Application Ref:	3/2025/0195			 Ribble Valley Borough Council <hr/> www.ribblevalley.gov.uk
Date Inspected:	22/07/2025	Site Notice:	N/A	
Officer:	MC			
DELEGATED ITEM FILE REPORT:				
				REFUSAL

<b>Development Description:</b>	Proposed first floor extension over existing garage to front.
<b>Site Address/Location:</b>	14 The Drive Brockhall Village Old Langho BB6 8BJ

Drawing Title:
Existing Elevations

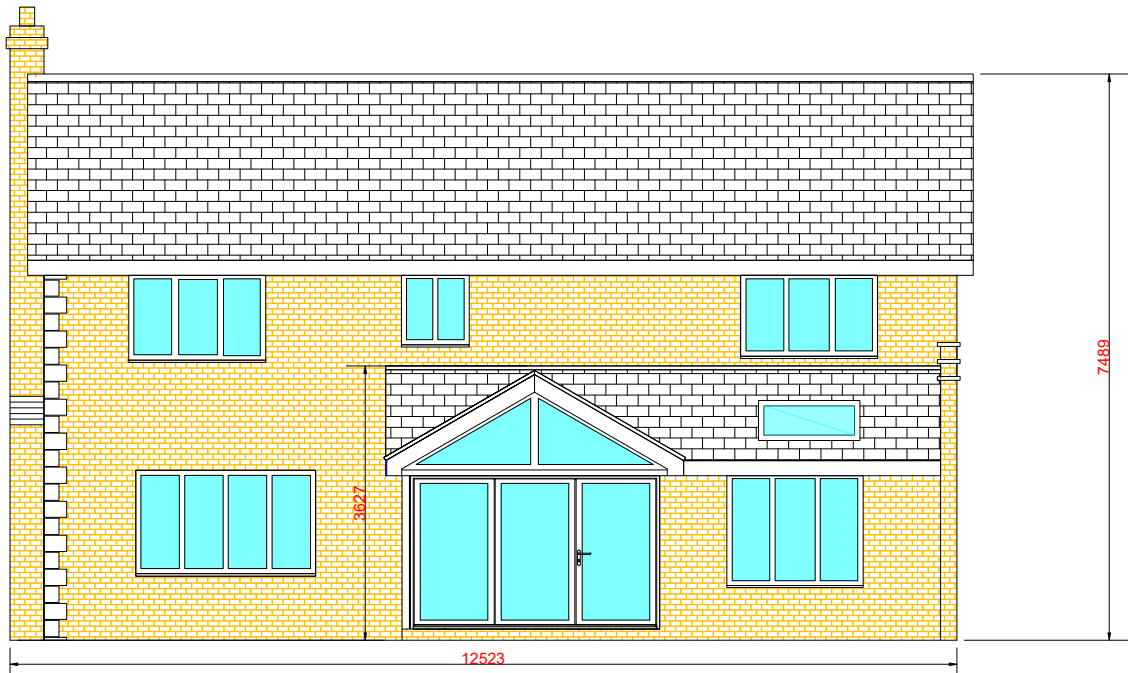
It should be noted that the drawings incorrectly show the height of the existing first floor outrigger to the front elevation which is slightly set down from the main roof ridge.

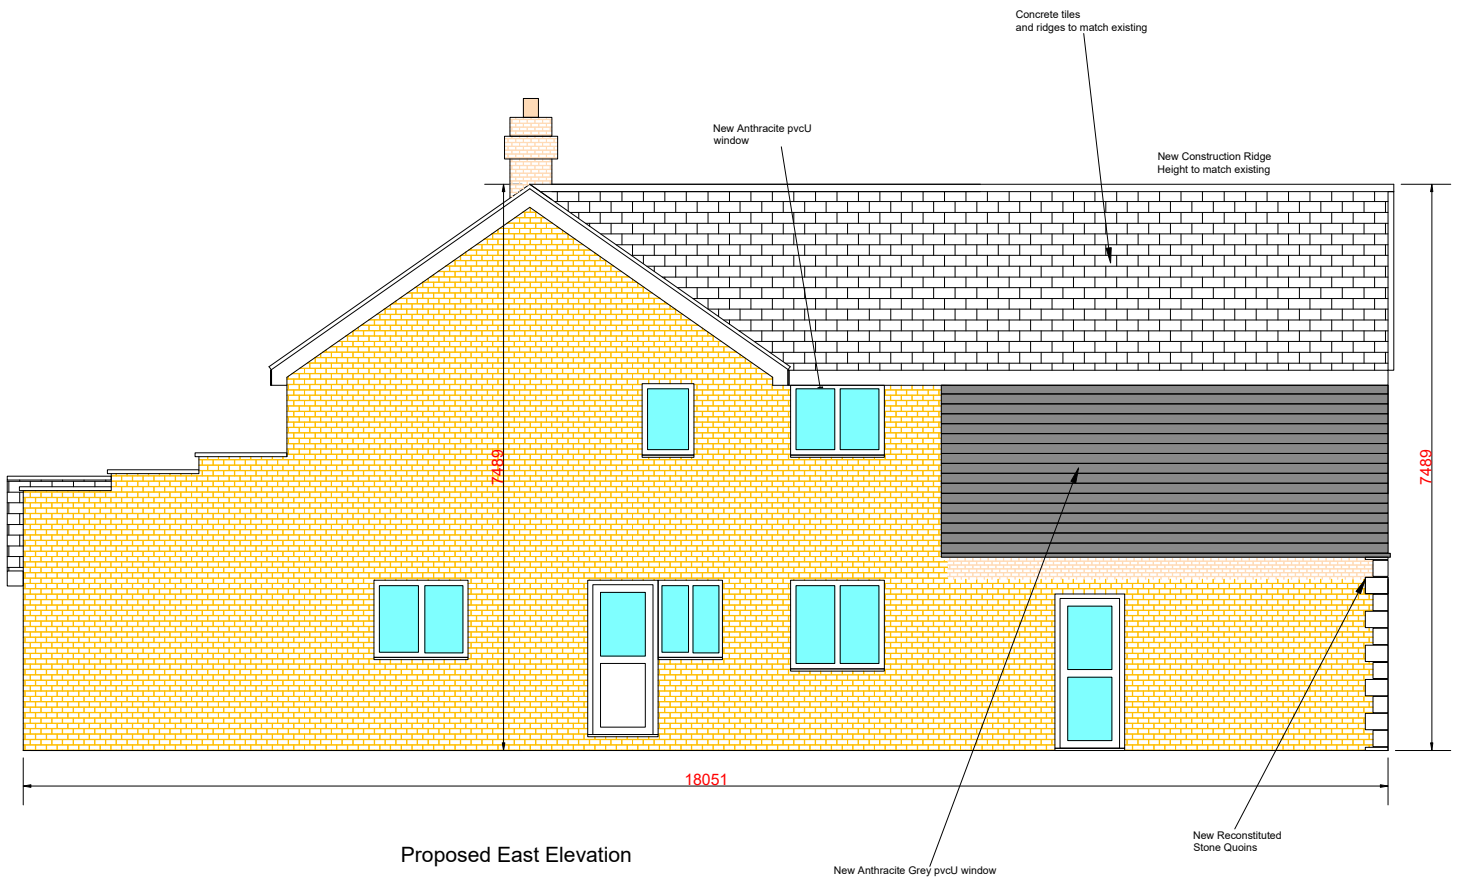
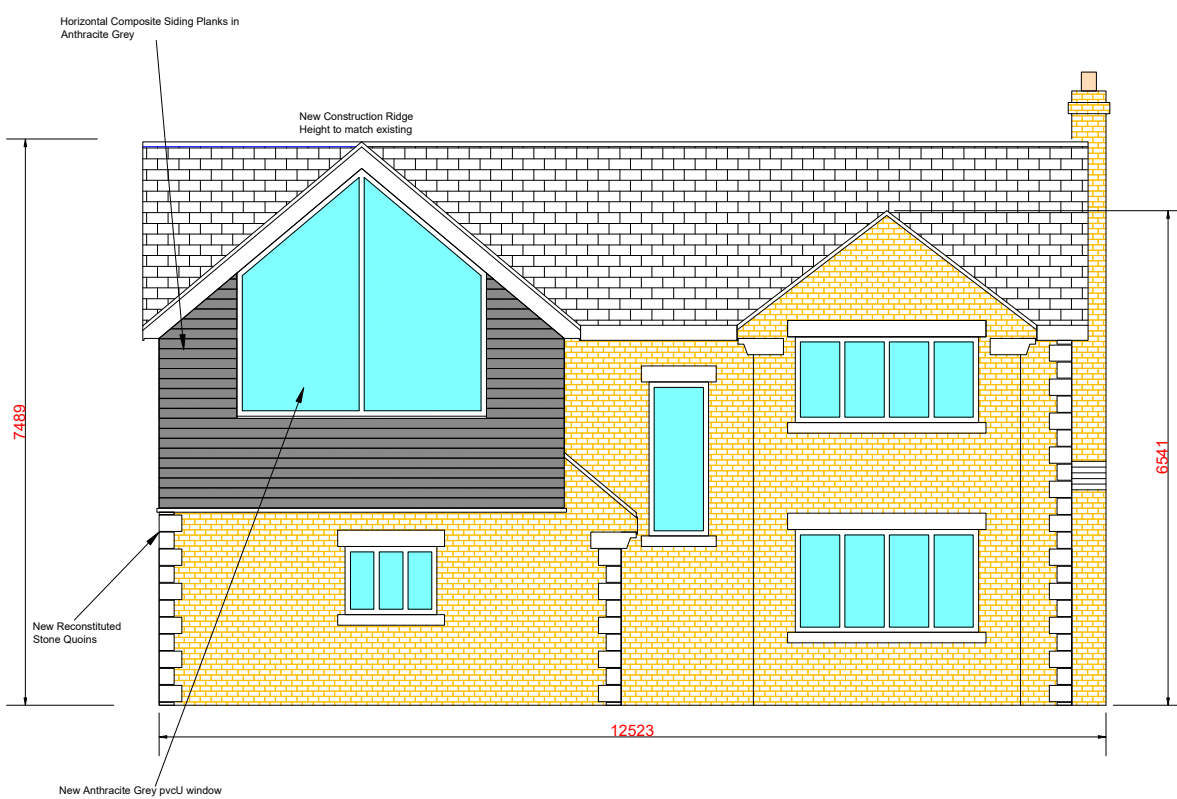
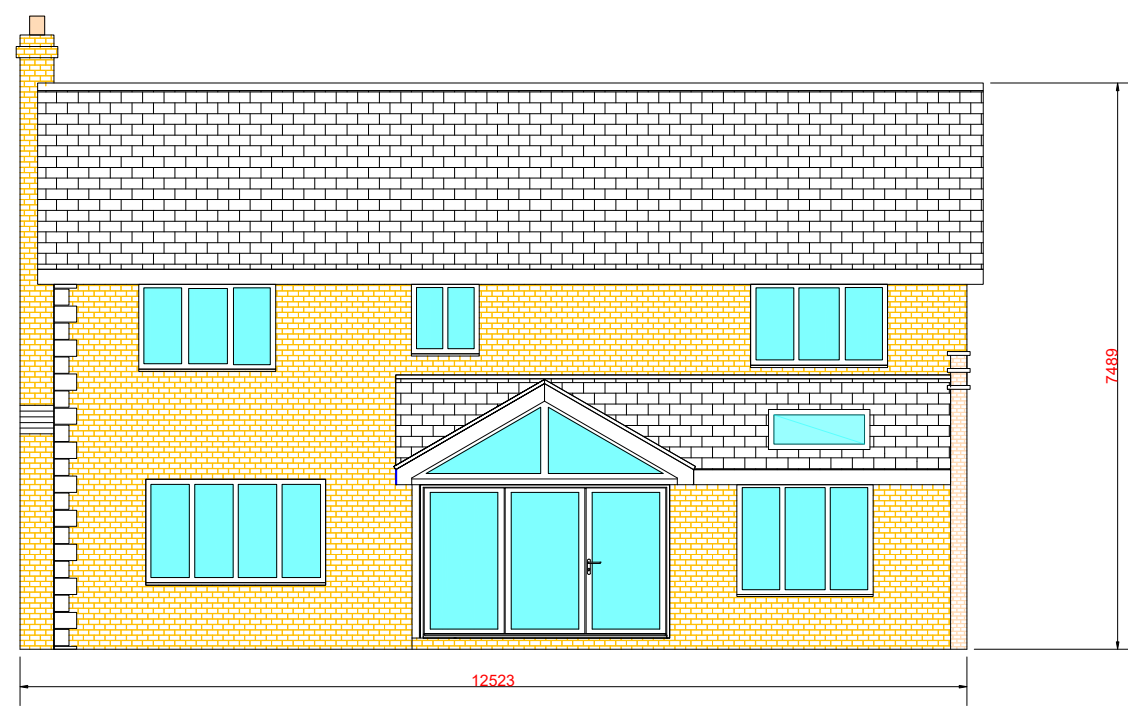
The proposed first floor extension would involve the raising of the roof to match the existing front gable projection with a total height of approximately 7.4m. The roof would have concrete tiles to match the existing with horizontal composite cladding boards to the first-floor walls in an Anthracite Grey colour. To the front elevation, a large, glazed window which extends up to the apex would be inserted. This would be in Anthracite Grey too, as well as a new uPVC window at first floor level to the side/west elevation

The proposed development would raise the ridge height of the existing garage element by approximately 2.2 metres.

The submitted elevation drawings indicate that the proposed extension would extend from the main roof ridge and extend from the existing first floor study to the depth of the existing garage, at approximately 5.6 metres. The proposed first floor extension would be fairly large in height and would extend at the same level as the

existing first floor outrigger to the front elevation and would not appear as a subservient addition to the main dwelling.

The proposal also includes the insertion of a number of new windows, including first floor side facing windows which would be Anthracite grey in colour. The windows on the existing property are currently white uPVC windows and the application form and submitted drawings do not indicate the existing windows would be replaced with grey uPVC to match the new windows. As such, the dwelling would have two different coloured windows in situ. The siting of the ground floor window would also appear off-centre with the first-floor glazed feature window which is considered harmful to the character of the dwelling.

The cladding proposed to the first floor would be added to all external elevations and the large, glazed apex window would be highly prominent within the street scene. Overall, the size, scale and design of the extension would not constitute a high-quality design and would not be sympathetic to the host building and would result in visual harm to the character and appearance of the site and surrounding area.

It should also be noted that the existing garage at no. 14 and no. 12 are approximately 2.8 metres apart. When compared to the distance at 'The Barn' which has a large forward gable projection, the distances between the gable and the neighbouring properties are over 4 metres which allows for views between the properties and retains a sense of openness. In contrast, the close siting of the proposed extension, in conjunction with the large depth, alterations to materials and the glazed feature window would appear incongruous with the adjacent property at no. 12.
